Our ref: NO/2025/117140/02-L01
Your ref: 3/2025/0873
Date: 03 February 2026

**CONSTRUCTION OF 6 DETACHED DWELLINGS WITH ASSOCIATED PARKING
AND LANDSCAPING AT LAND OFF SPRINGWOOD DRIVE.**

LAND AT SPRINGWOOD DRIVE, WHALLEY, BB7 9XL

Environment Agency position

Drawing Title			
EXISTING TOPOGRAPHIC SITE PLAN			
Drawn by PD		Checked by	Date 04.02.26
Suitability S2		Scale @ A1	1 : 250
12477	SWD-CAA-ZZ-ZZ-D-A-1005	P6	
C+A JOB NO.	PROJECT - ORIGINATOR - VOL. - LEVEL - TYPE - ROLE - NUMBER	REV.

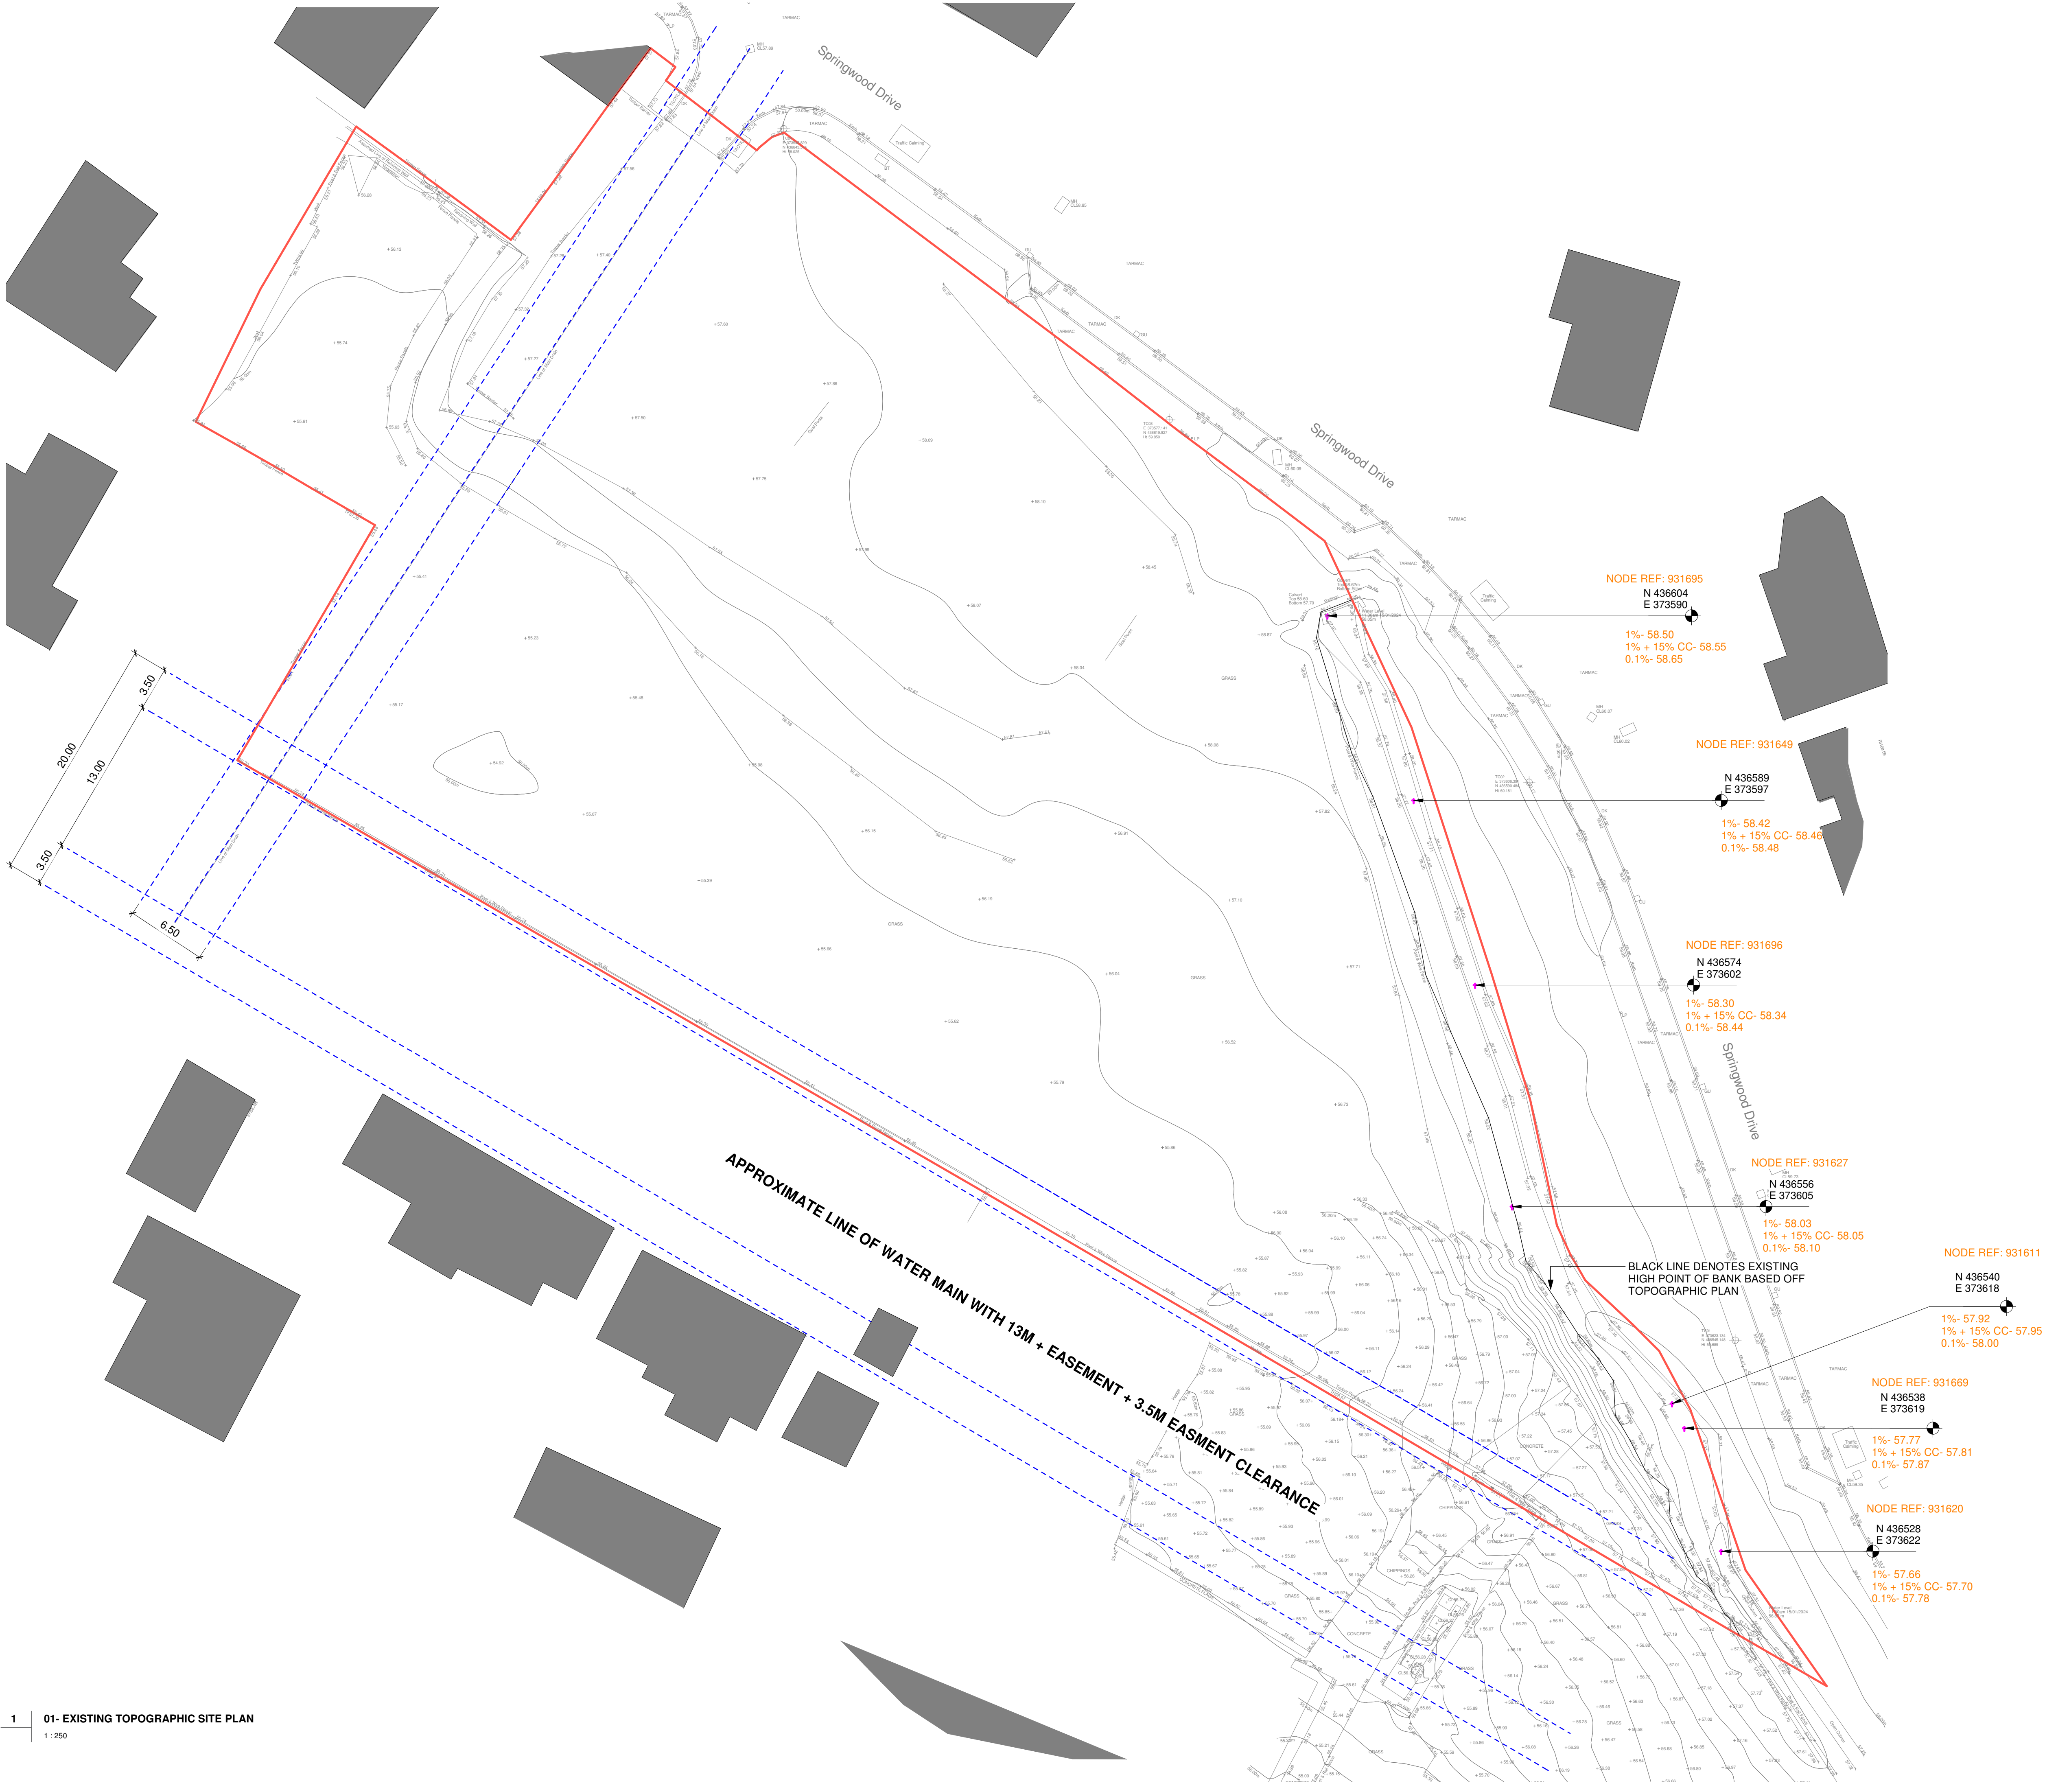
The existing topographical survey in Appendix D of the FRA remains illegible. Please submit the topographical survey in a fully legible format (either as a standalone PDF or within an updated revision of the FRA).

The topographical survey is essential to our review, as it will determine our assessment of flood risk at the site and inform our detailed comments. We are unable to complete our review without it.
